Application No: FG/57/22/PL  
Site Address: 12 Little Paddocks Ferring BN12 5NJ  
Description of works: Demolition and erection of 1 No new dwelling. This application is in CIL Zone 4 and is CIL Liable as new dwelling.

Thank you for your internet representation made on 12th May 2022 which has been recorded as an objection with the comments as follows:

DRAWING No.
**Drawing 1
Existing & Proposed
Floor Plans & Elevations**

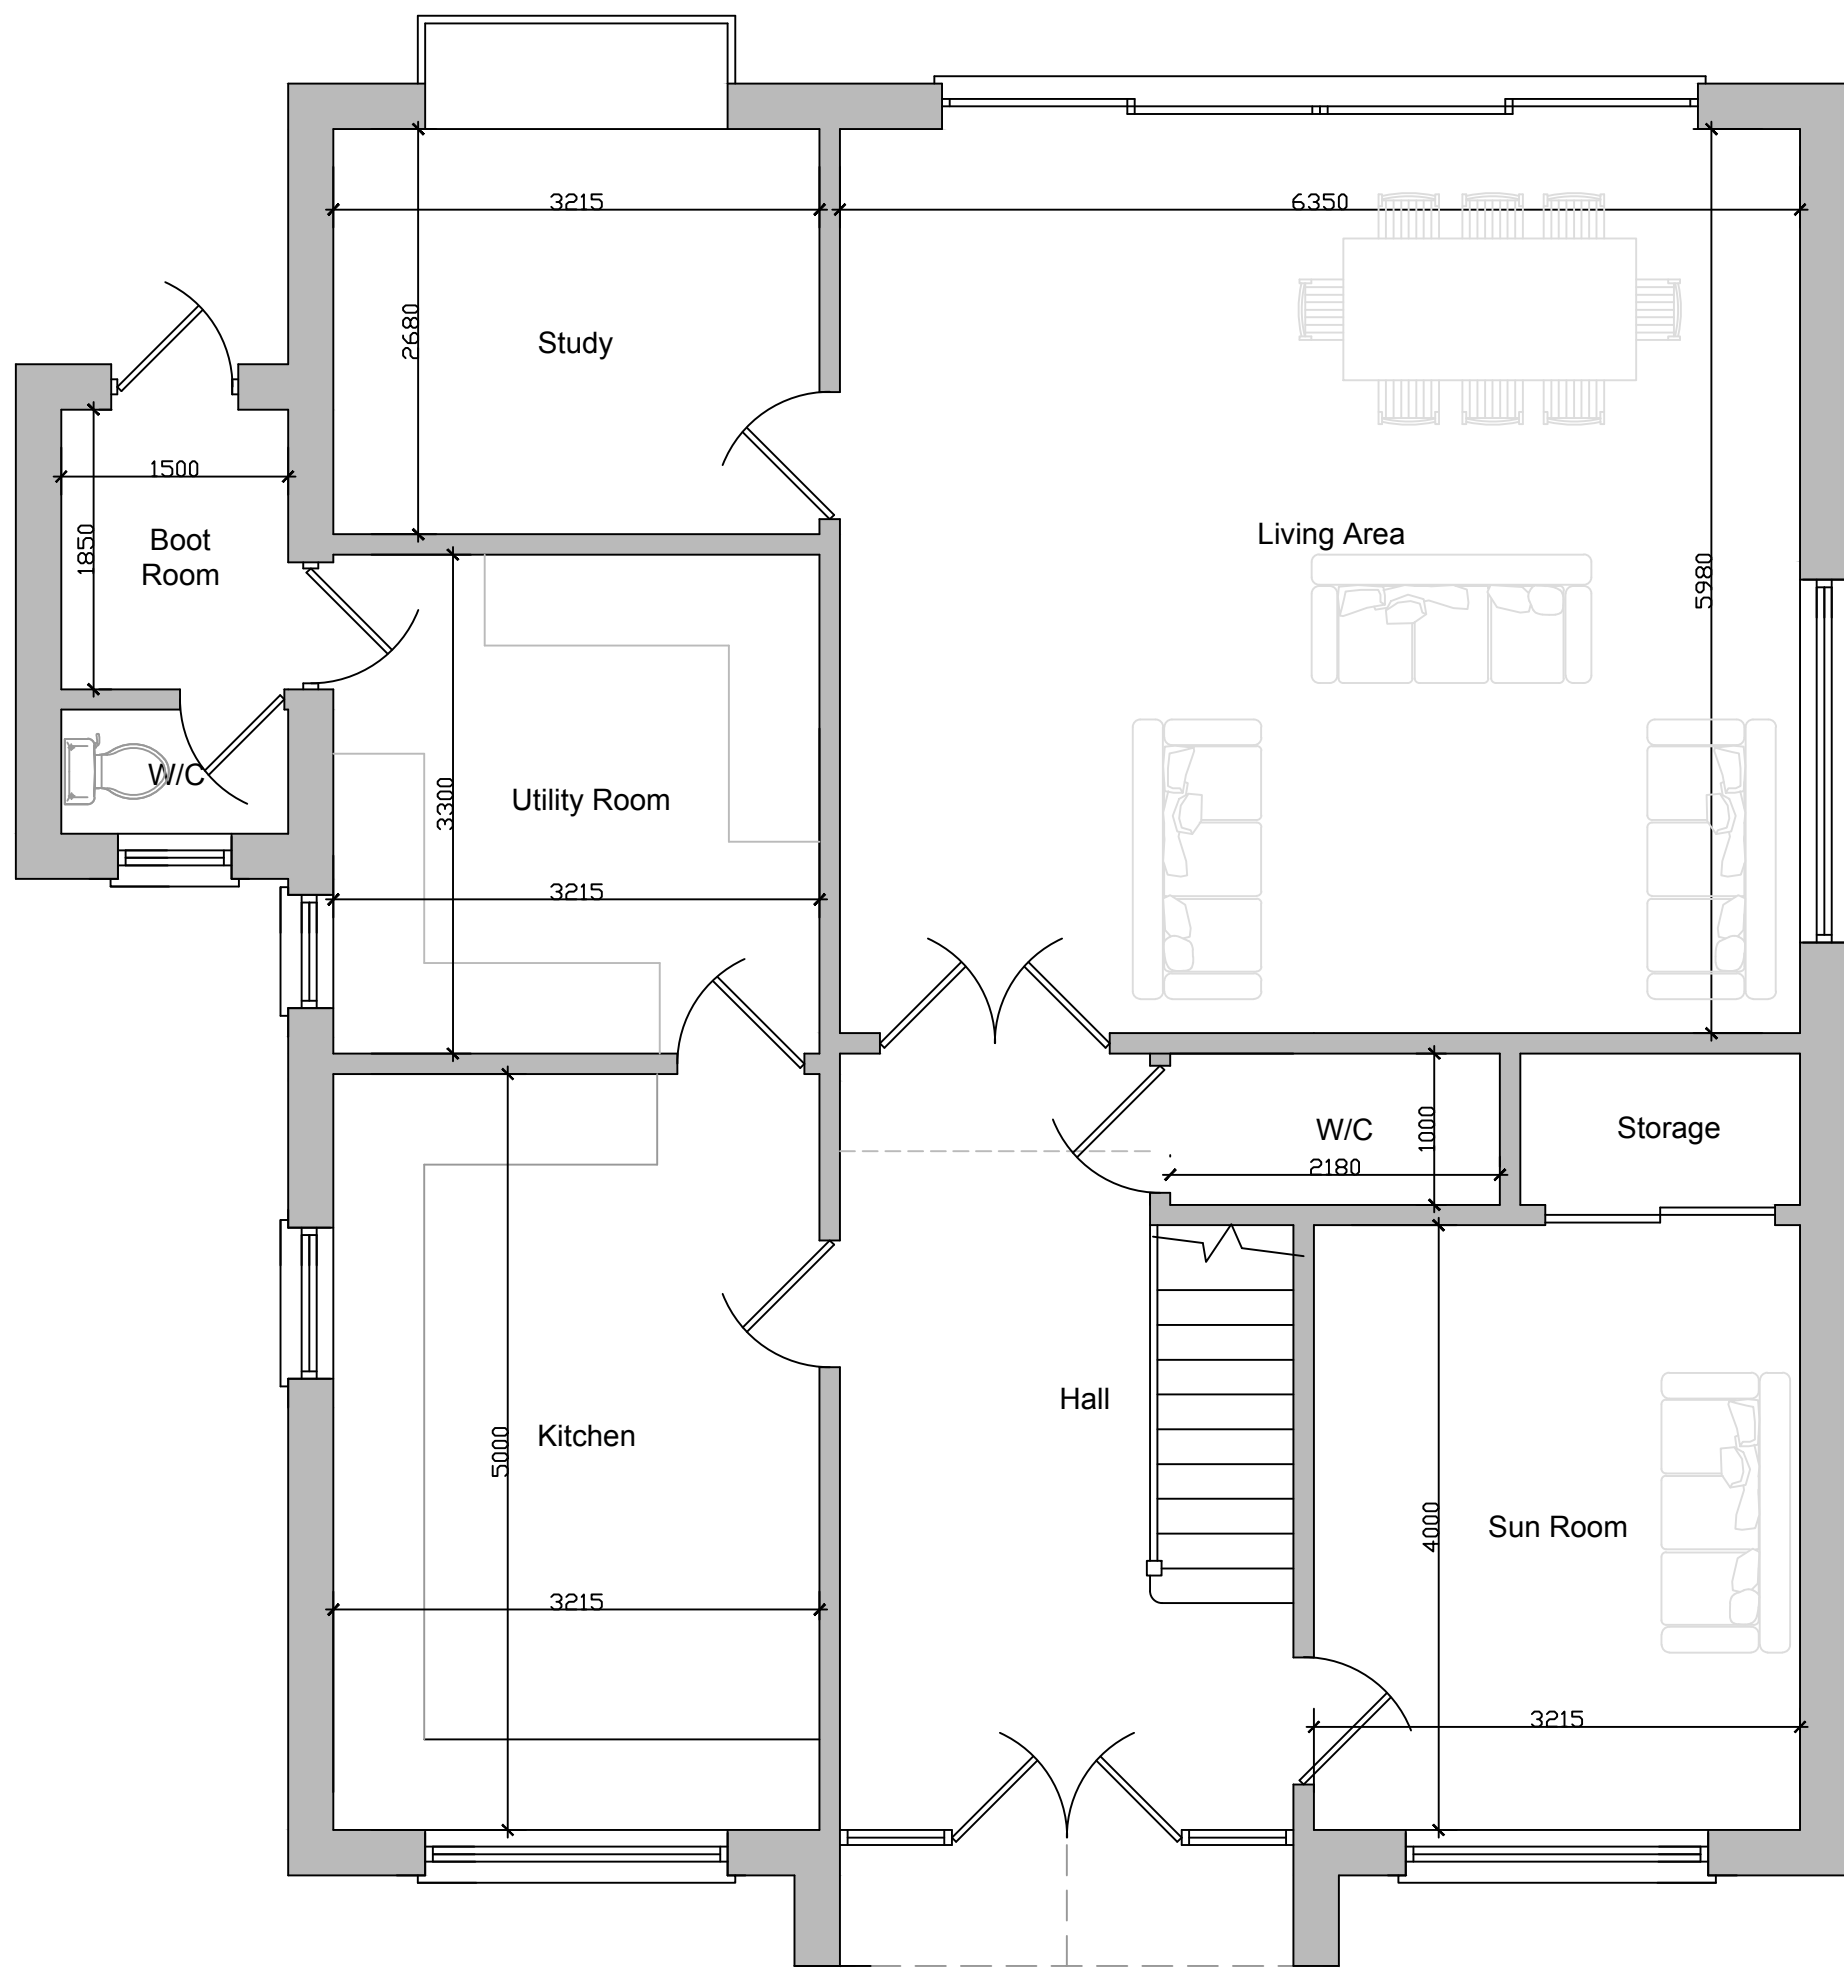
We believe the proposal will result in overlooking and a loss of privacy to both adjacent properties, No's 11 & 13 Little Paddocks and also to subsequent neighbouring properties.

In particular an overshadowing of and a loss of light to No 13 Little Paddocks which is situated to the NE of the new dwelling. (Arun Local Plan D DM 1.3 Impact)

Furthermore, we feel the design and appearance, although subjective, of the elevations are in stark contrast to the characterful bungalows of the unique northern green space of Little Paddocks and appear not to be in harmony with the distinctiveness of the wider setting, paying little regard to the current spatial amenity and pattern of the street scene and therefore will not positively contribute to the locality. (Arun Local Plan D DM 1.1 Character)

Drawing 6
Proposed Street Scene
& Site Plan

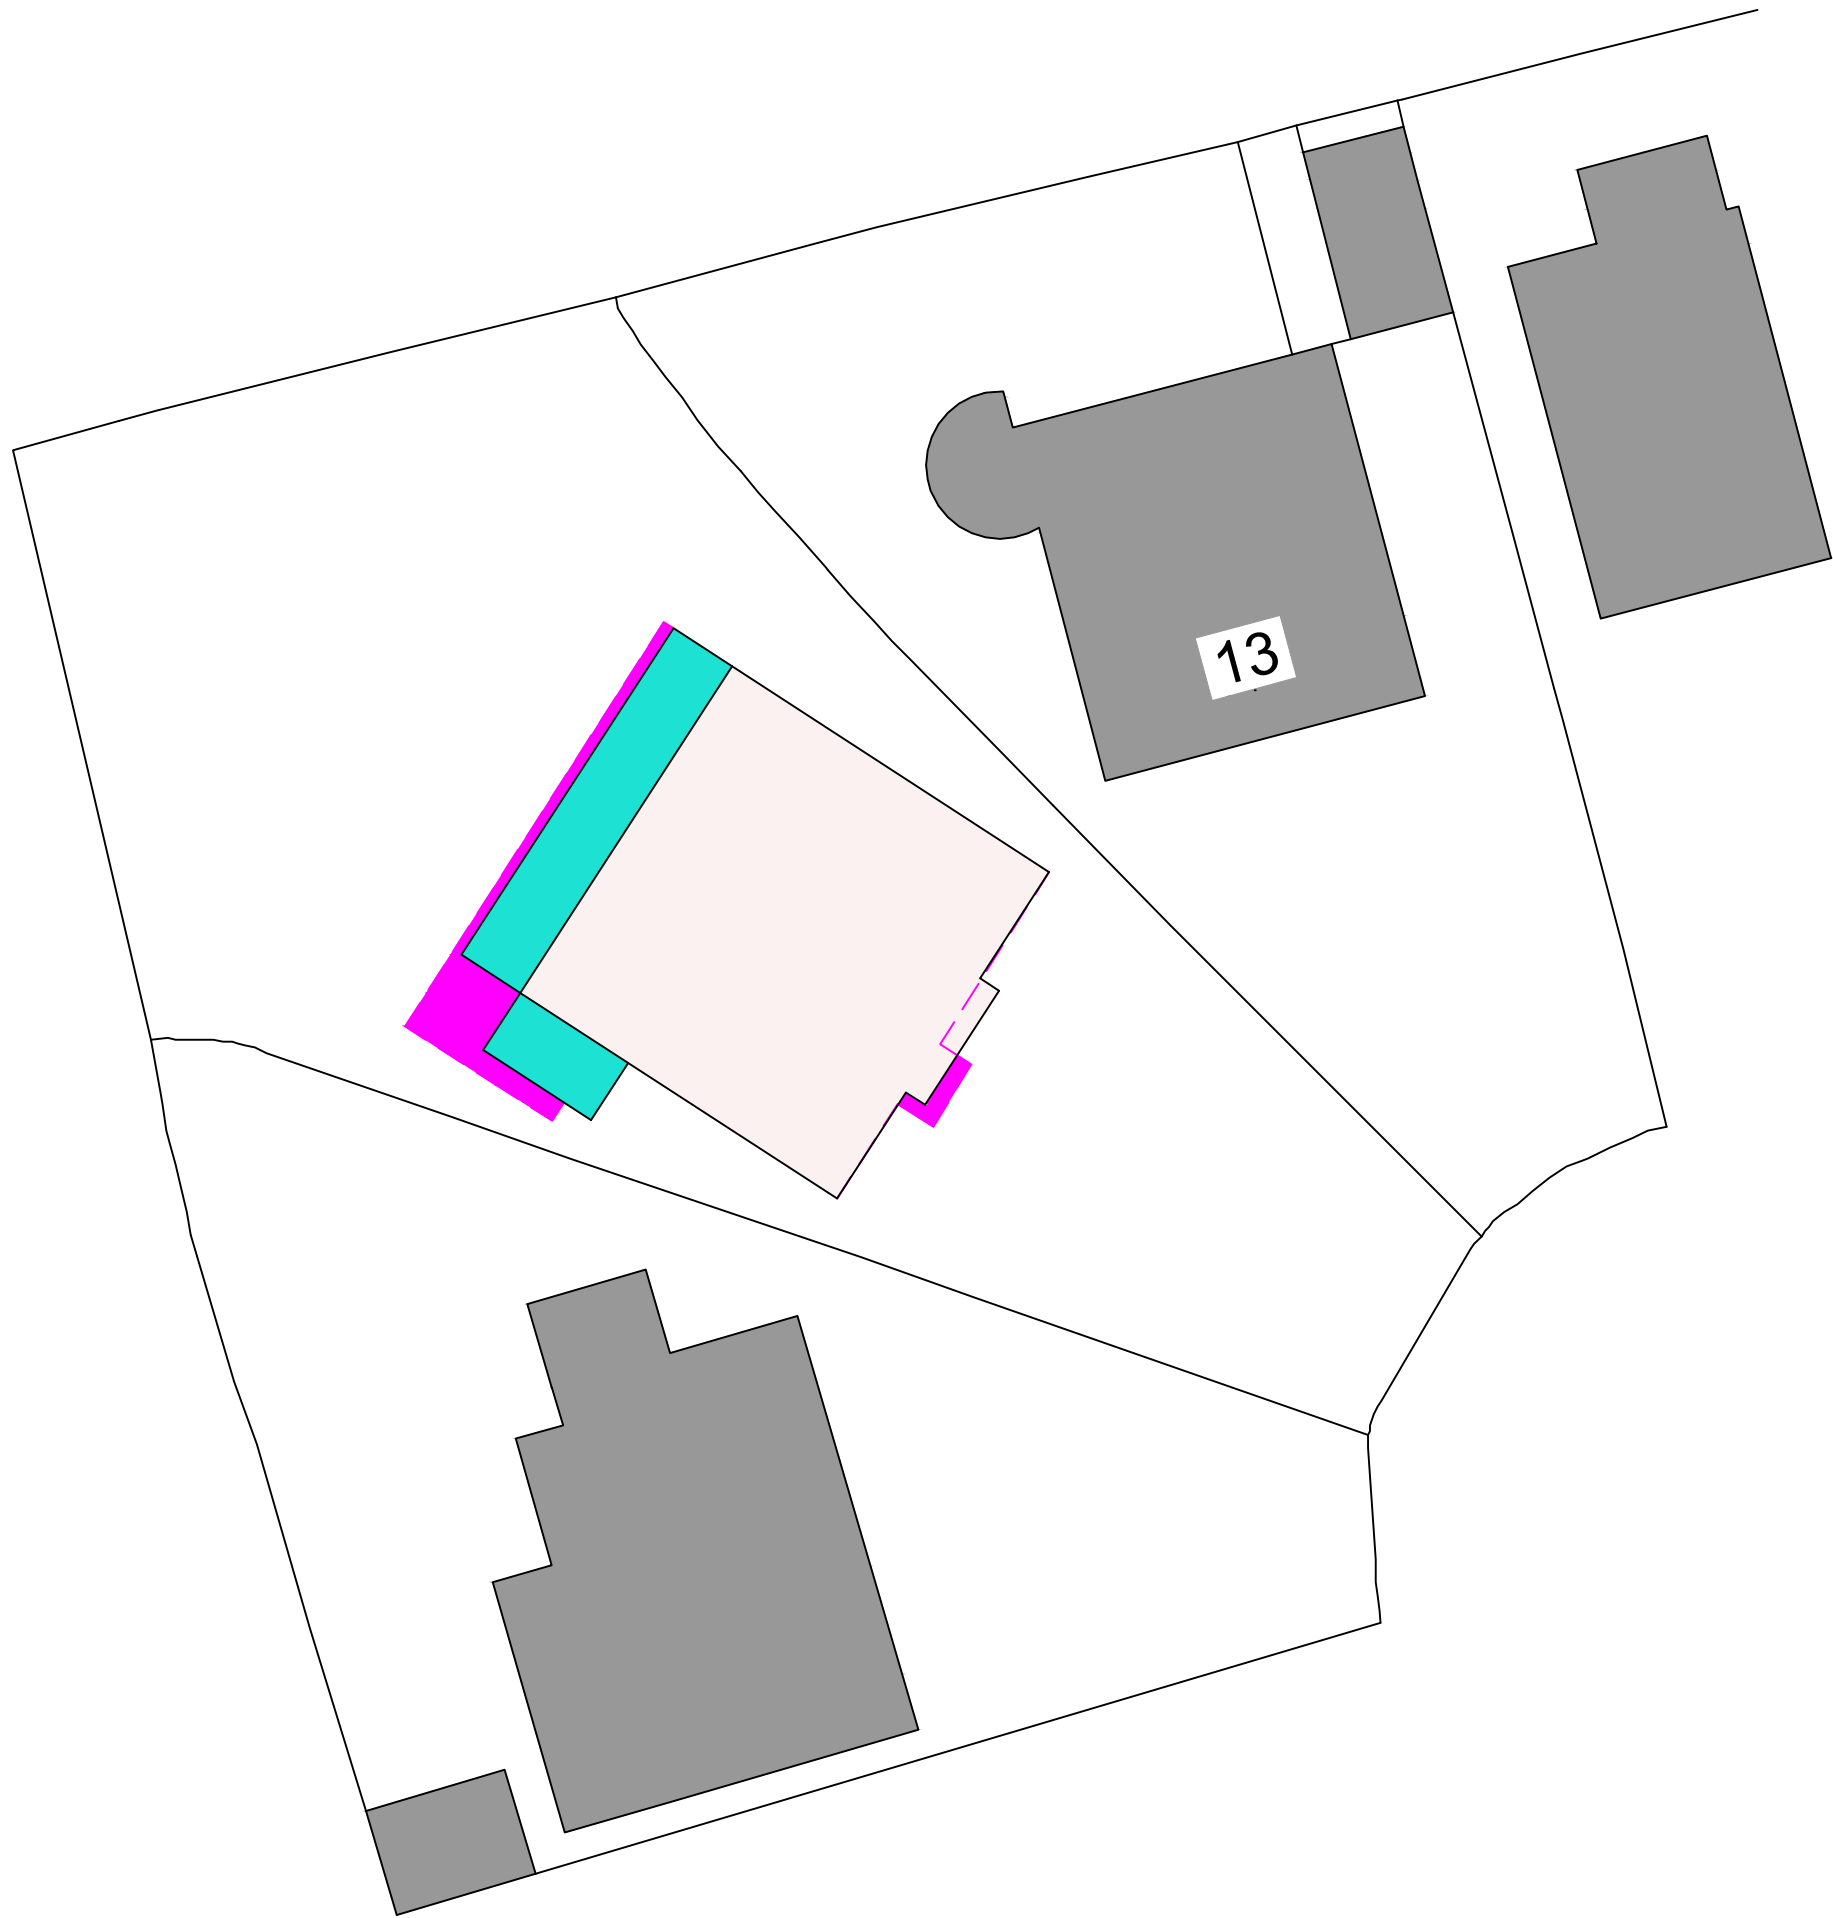
We consider the Street Scene renderings supplied with the application are not reflective and for clarity attach a number of photographs, in addition we feel a site visit by the Planning Officer may prove enlightening before progressing.
